Our Ref: WA/95/18/RES

Application for Approval of Reserved Matters Following Outline Approval

Development Approval of reserved matters following outline consent WA/44/17/OUT for the erection of 175 No. dwellings, car parking including garages, internal access roads, footpaths, parking & circulation areas, hard & soft landscaping, allotments, play areas/equipment & community orchard & other associated infrastructure & engineering works. This application may affect the character & appearance of the Walberton Village Conservation Area.

Location Land east of Tye Lane Walberton

SCALE	DATE	AUTHOR	CHK'D
1:100 @ A3	Oct 18	PZ	
JOB NO.	DRAWING NO.	REV	
LIND171208	GAR-2.pe	A

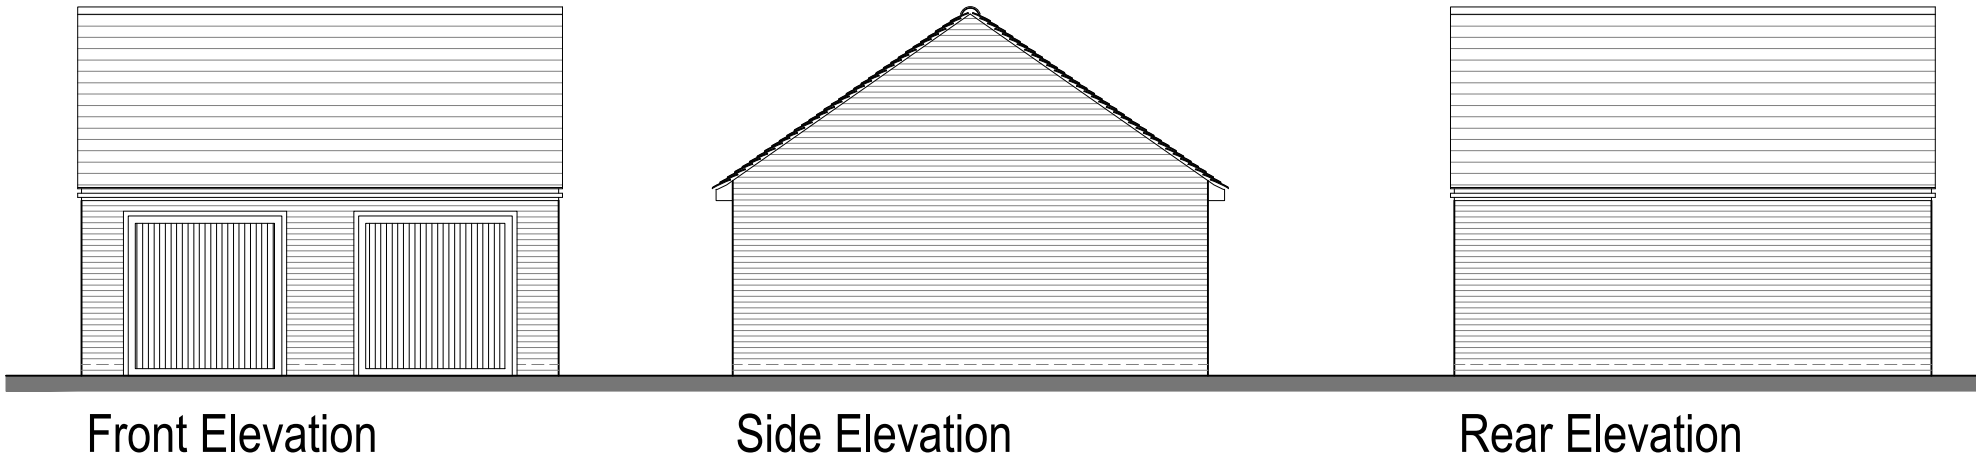
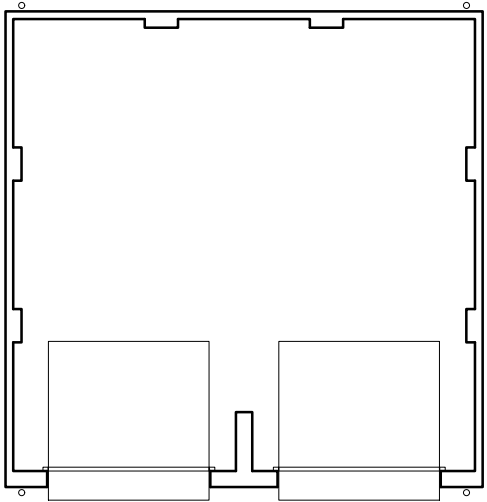
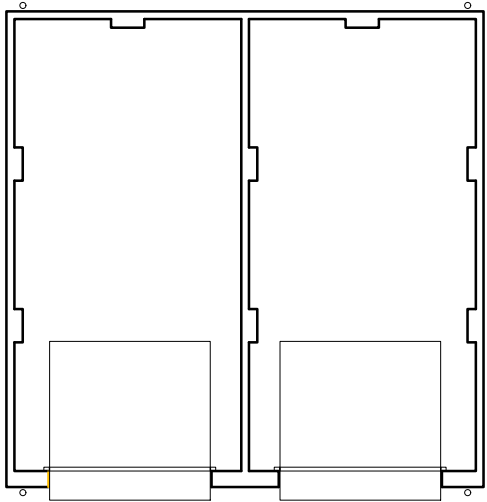
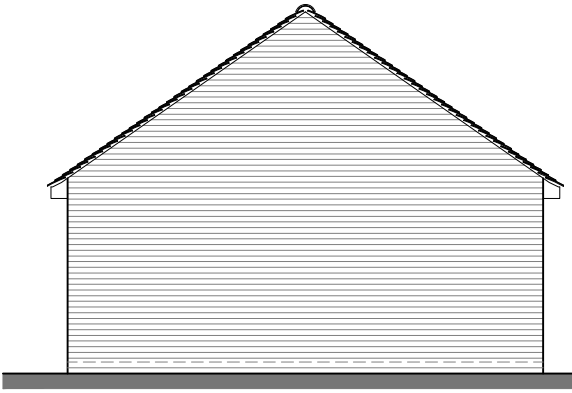
Plan GAR-2.pe reva and GAR-2.pe revb, two front elevations have been labelled. Please label one as rear. Please amend the plans accordingly.
